Objection

I reiterate my previous objection and add the following comments in response to the revised plans which now access all 8 flats from Sea Drive and show the building raised up to 7m in height.

BASEMENT FLOOR PLAN

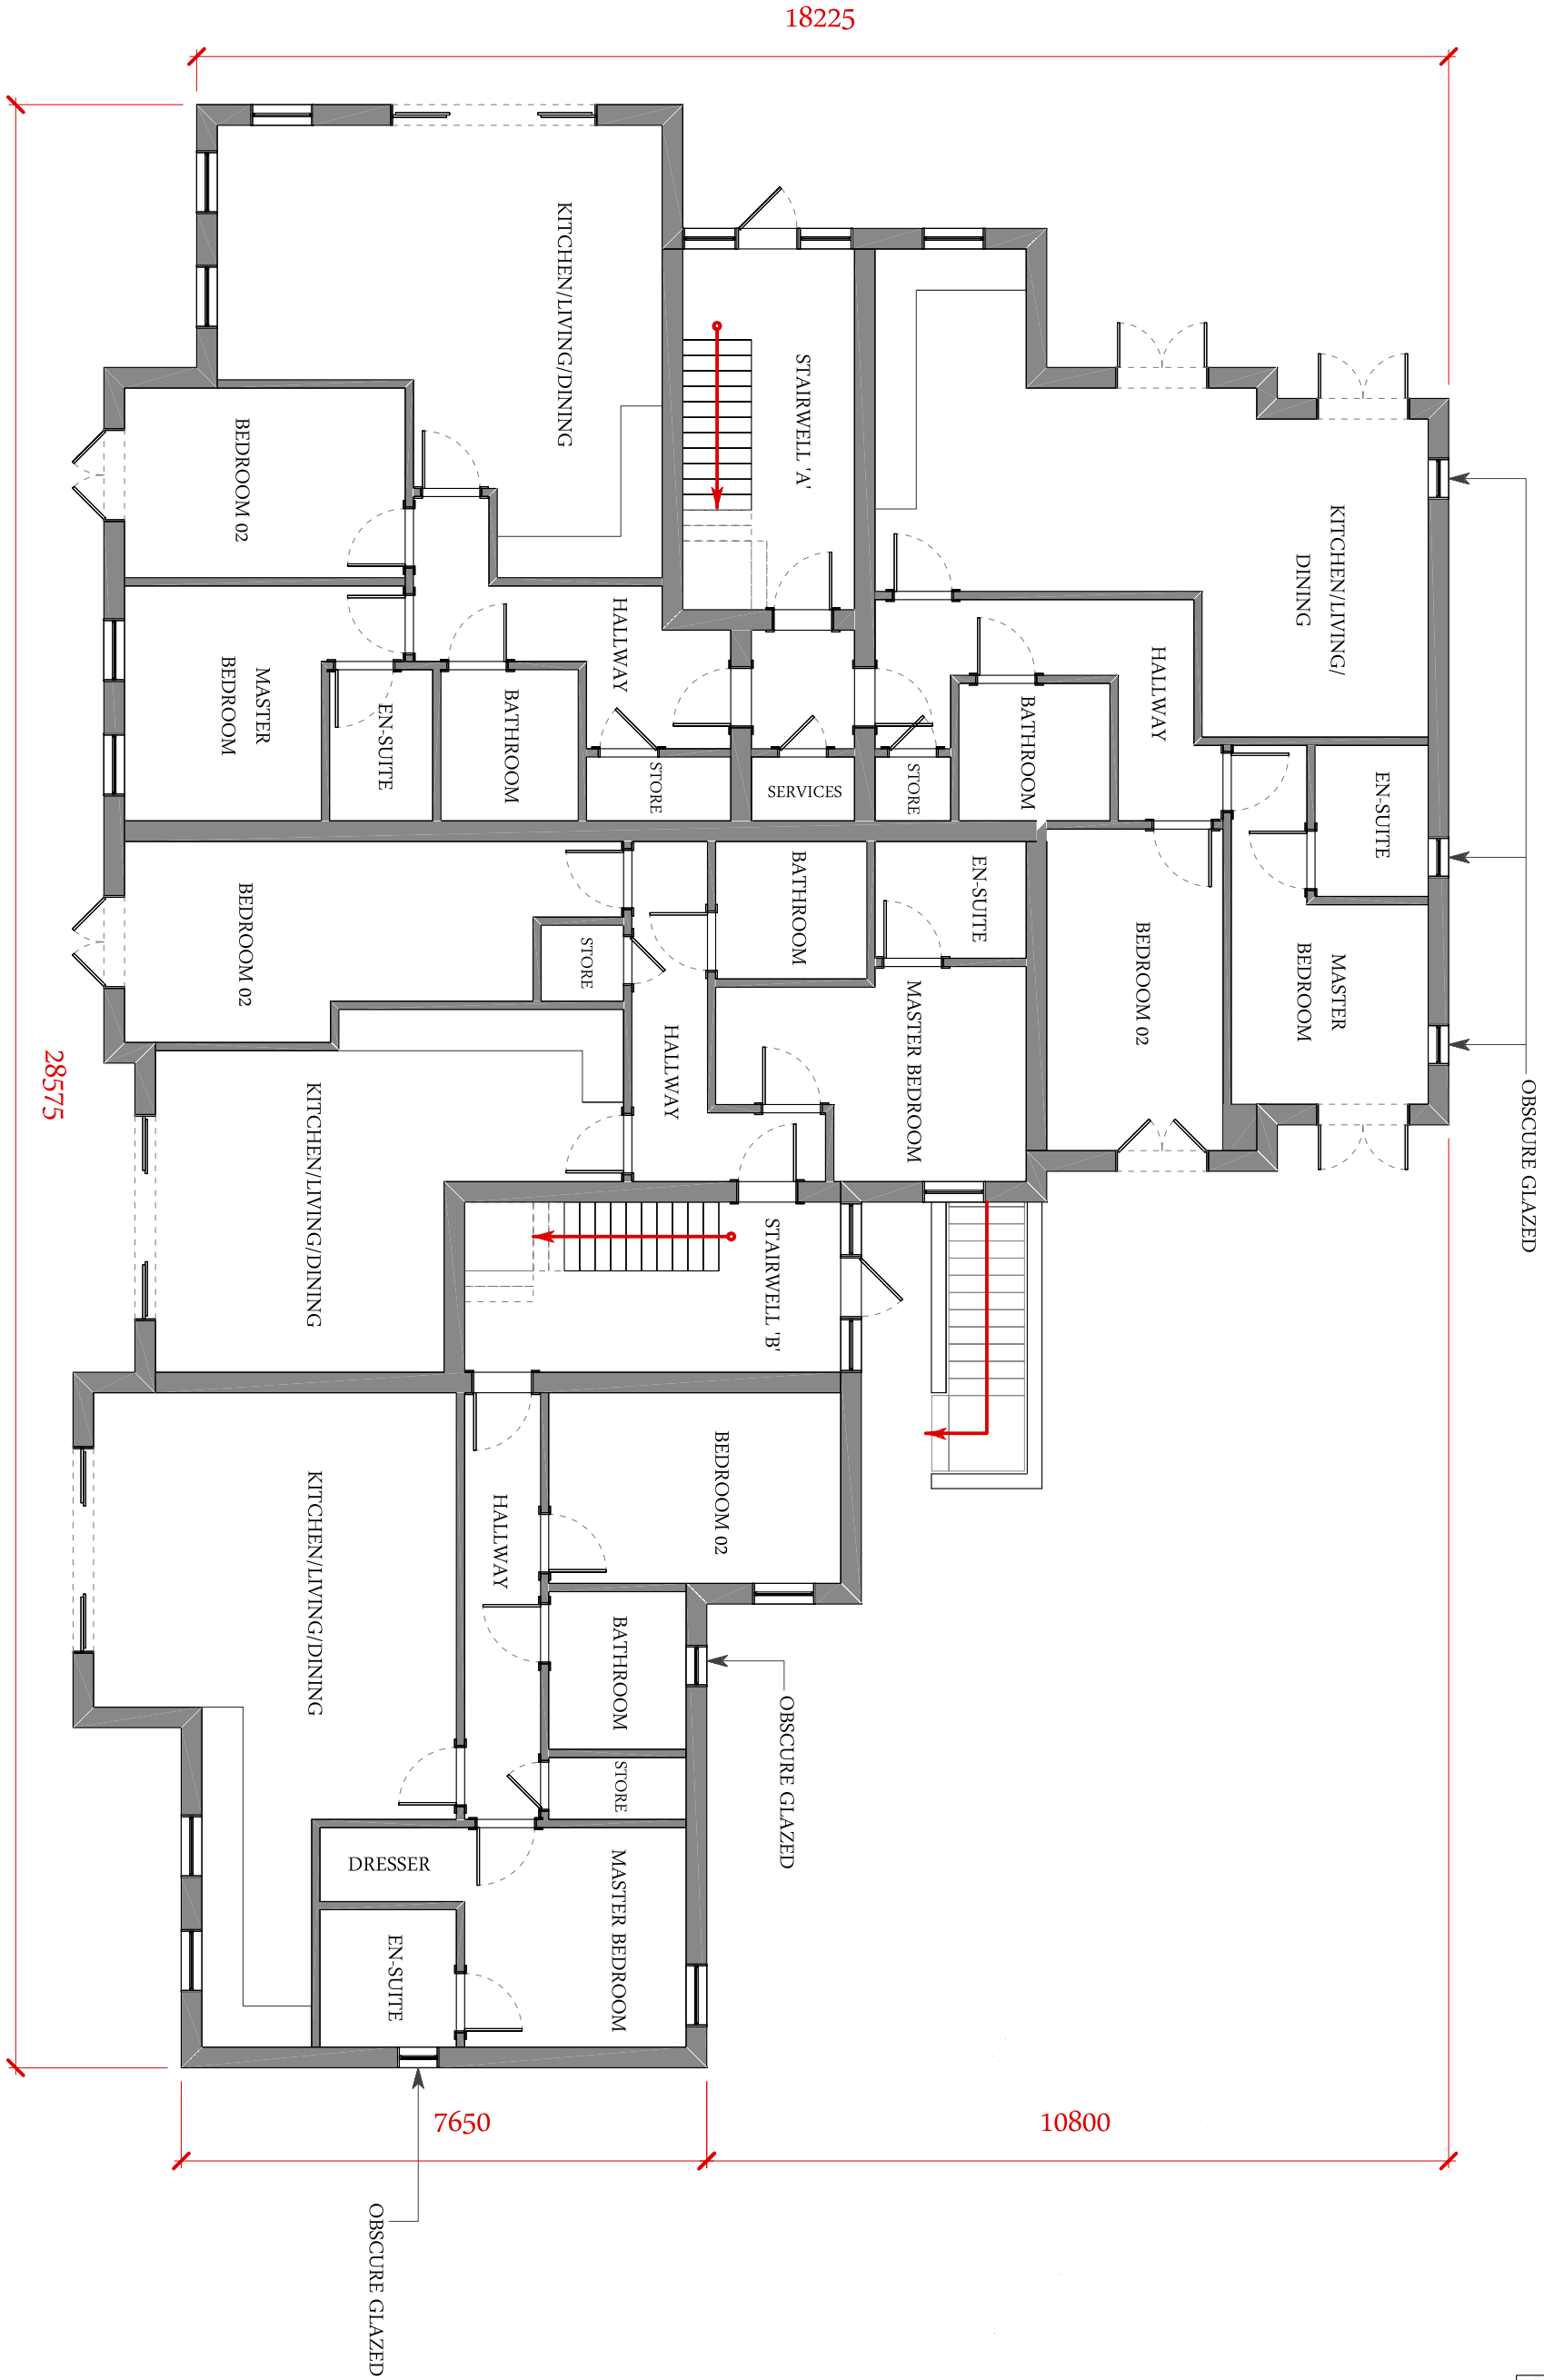
The underground car park does not allow enough manoeuvring room for cars to turn in order to exit forwards. Cars would therefore potentially reverse up the ramp and into Sea Drive.

Contrary to GEN 7 and GEN 4 Arun Local Plan and DEV 1 West Sussex Structure Plan - There appears to have been added a pedestrian footpath down the West Side of the block to the rear entrance. This seems to merge with the car park ramp towards the front, which is impossible given the levels, and obviously very unsafe. It will also result in pedestrians popping out onto Sea Drive from behind a high hedge next to our driveway which is not safe. The rear flats still have no safe access to the bin store. This path and the associated use, noise and lighting will result in an unacceptable loss of enjoyment to our balcony and master bedroom.

PROJECT: 1 SEA DRIVE
HARRISON WORTHING
BRIEF 5/10
TITLE: PROPOSED ELEVATIONS
AND STREET SCENES

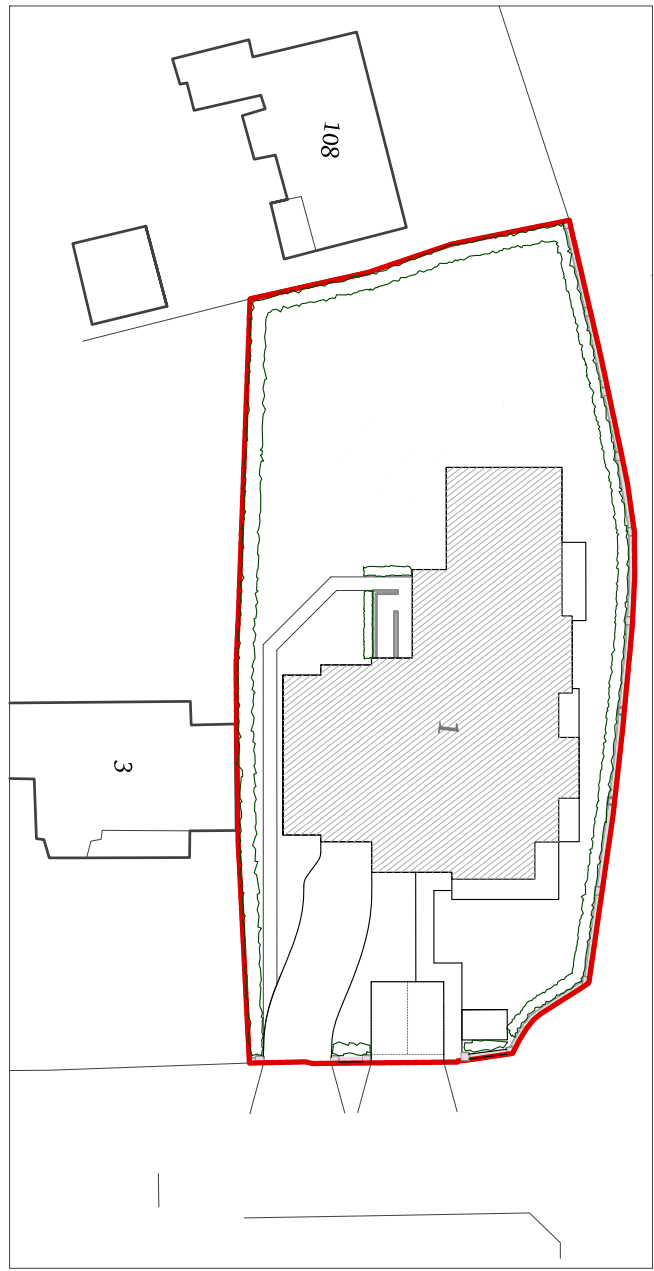
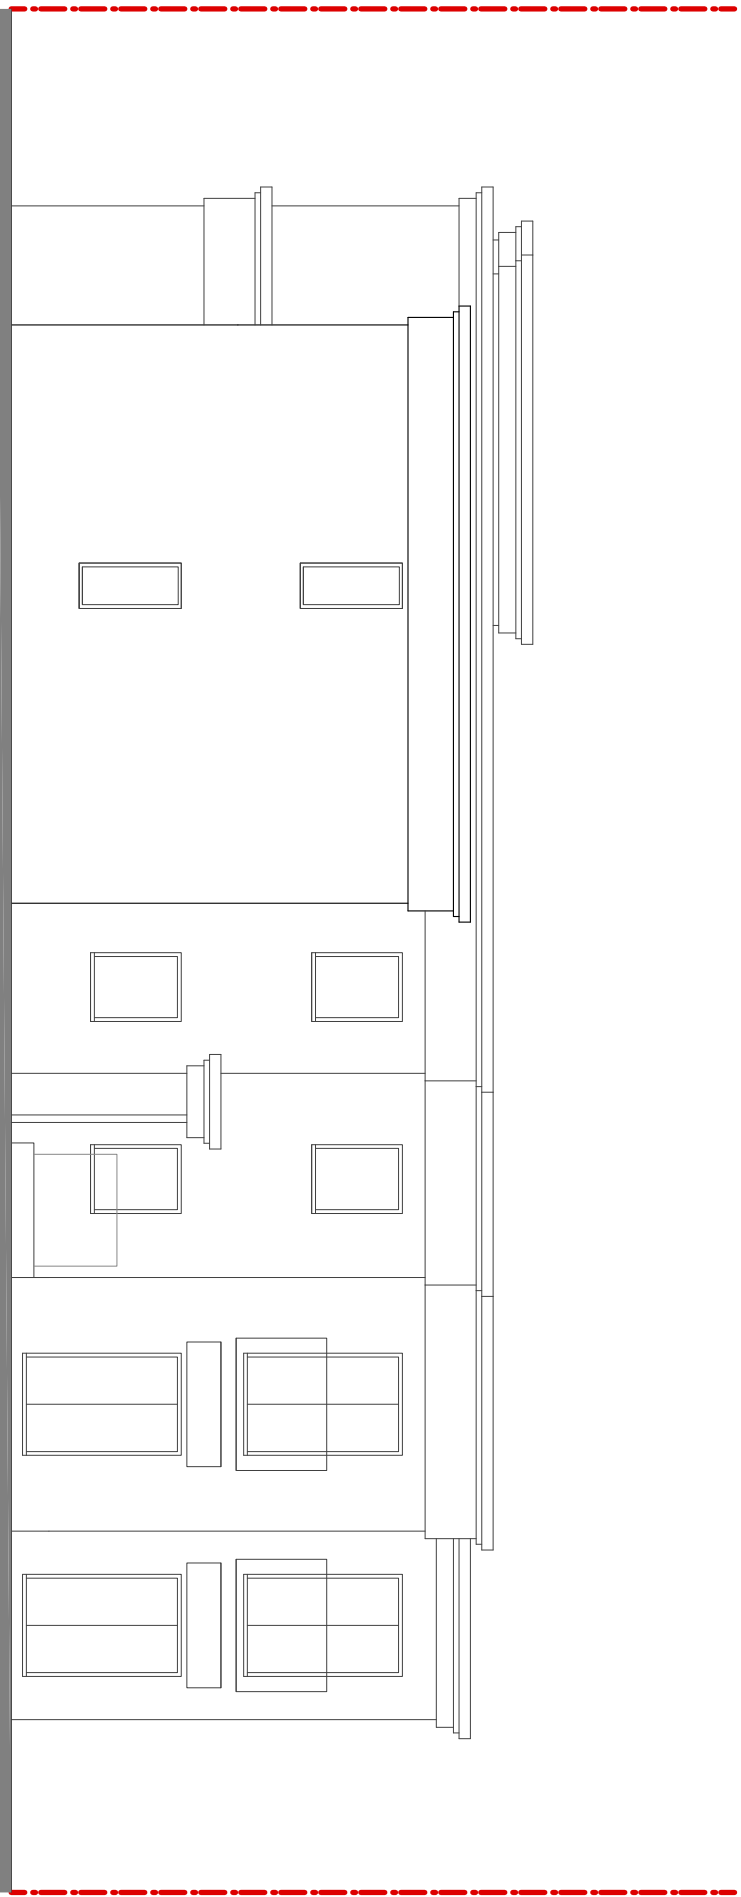
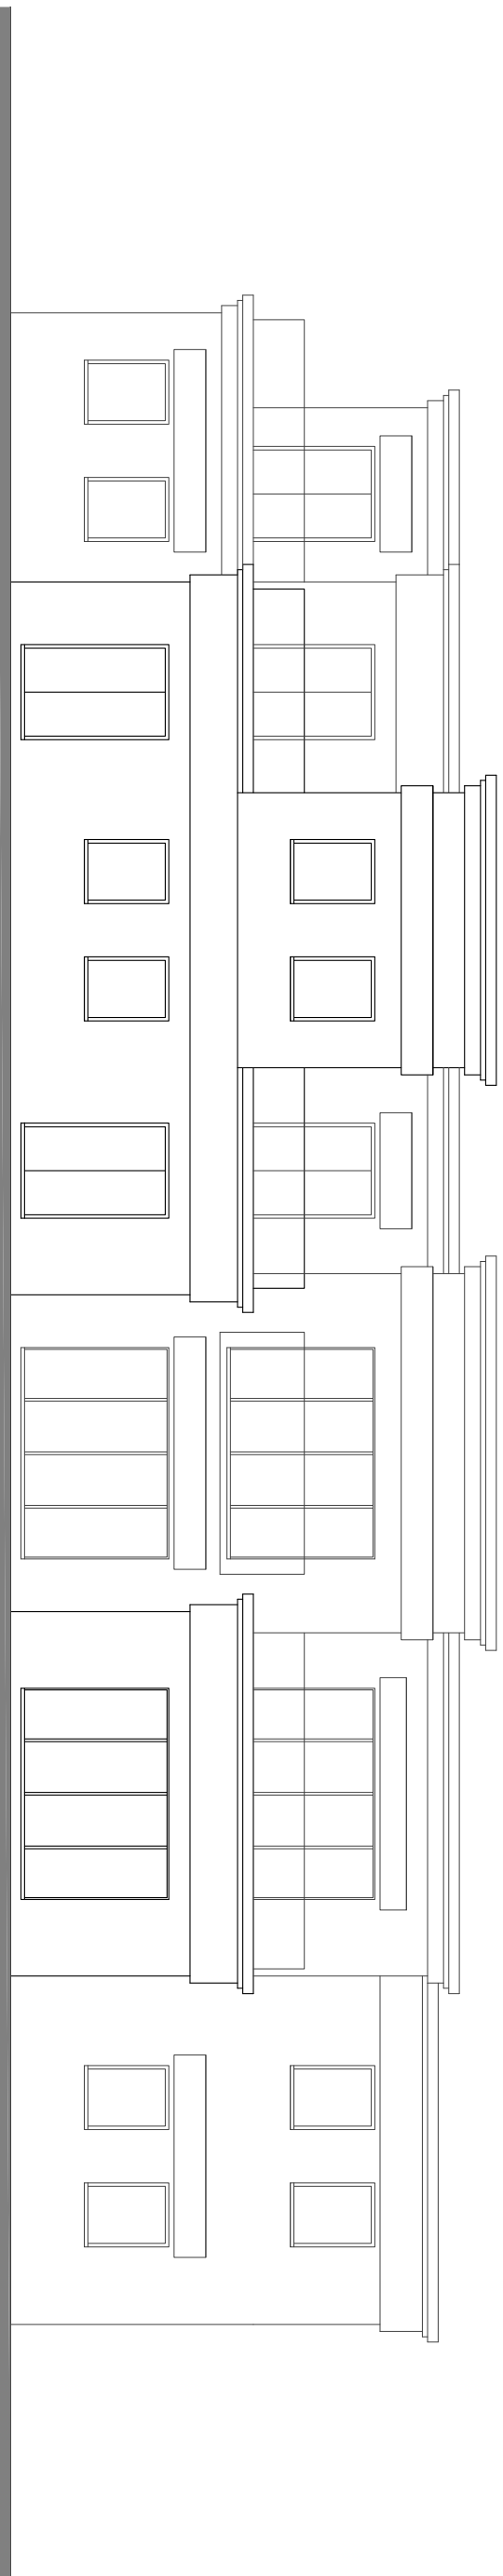
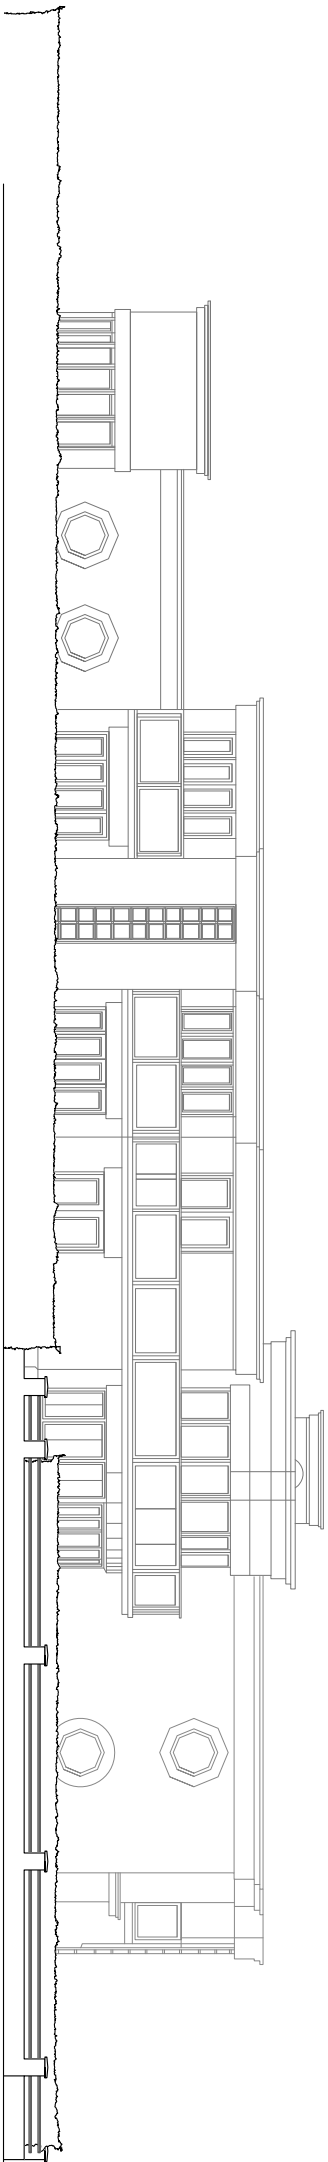
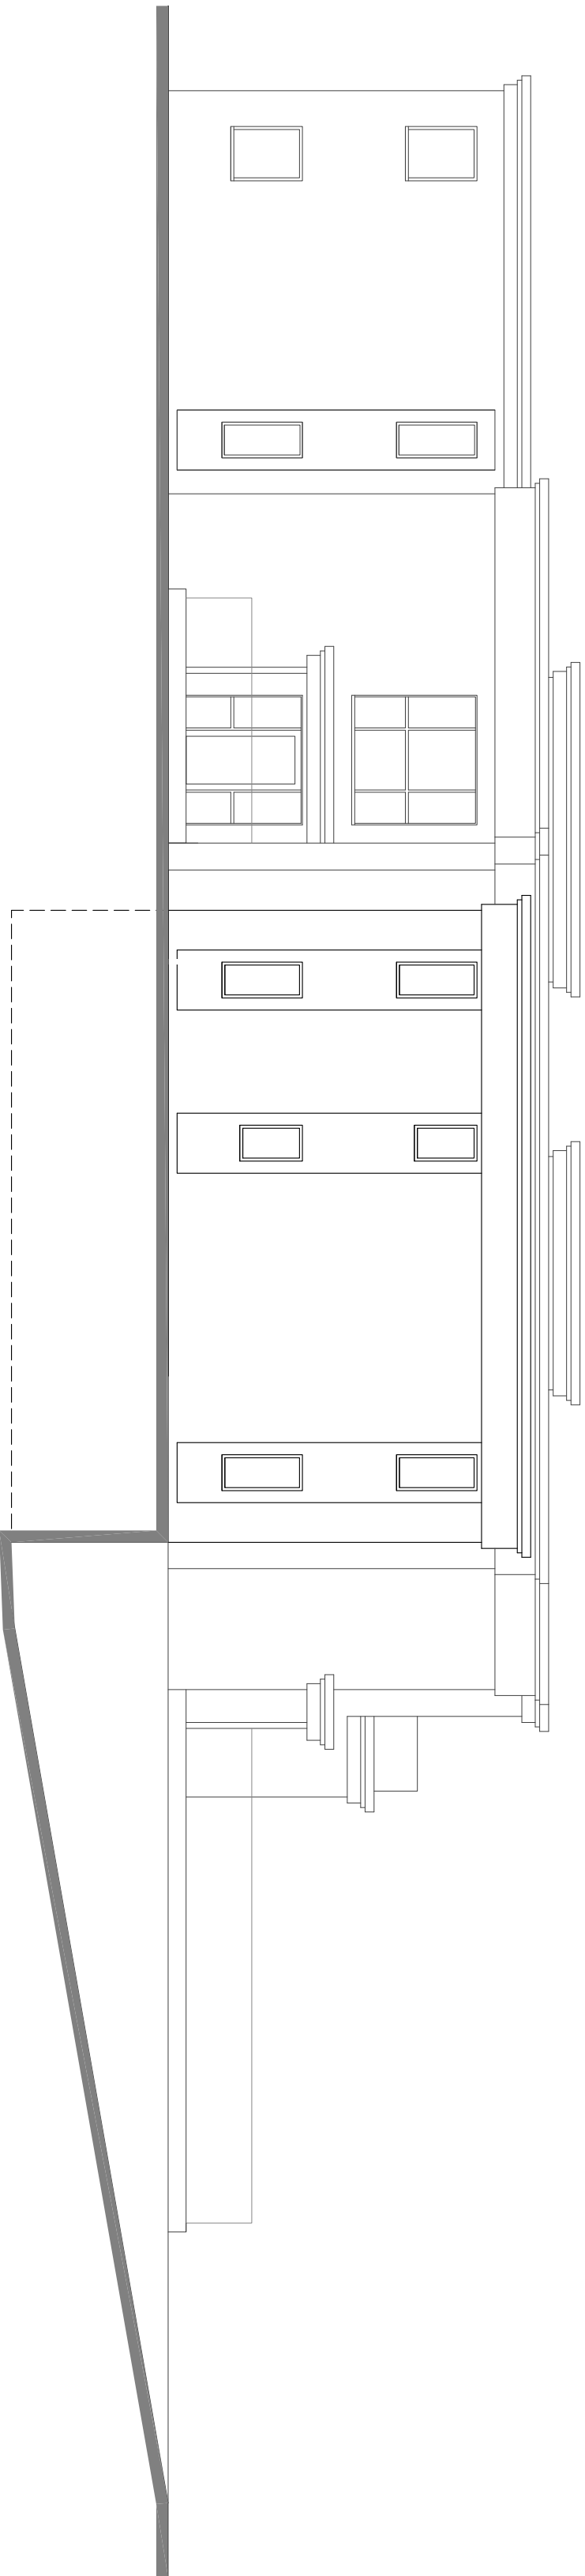
The revised plans show the building raised to 7m in height with the ground floor sitting well above the ground floor of our property. My understanding is that this is to protect the new flats from flooding, however the effect that this has on the street scene and our property is

that it is entirely dominant, substantially higher than our property with a flat roof, so the overbearing, overshadowing and overlooking aspects will be unbearable, contrary to **DEV 1 West Sussex Structure Plan**. The open view of the sky from the rear of our house will be lost by this very high building protruding so far behind the back of our property and all sun into our East family room window will be lost.

The fact that the windows and doors will be raised means that the overlooking will come from the ground floor whose windows will be above fence height and the first floor.

The existing building has 1 obscure window that faces our property. The original proposal showed 10 windows facing us and the revised proposal shows this has now increased to 12 – only some of which are obscure, 2 of which are very large and many will likely be opening windows. If this is allowed, we will lose all privacy in our front garden, on our newly constructed balcony, in our rear garden and even in our family room since the additional bedroom windows will offer a direct view into the rear of our house- straight into our family room. This overlooking will all be from vantage points that the additional height creates.

The current views of the fields that we have from our property will be entirely blocked by this build and there is a window shown that will look directly onto our balcony from higher than our first floor level. We would find this unacceptable even if it was obscure and non opening.
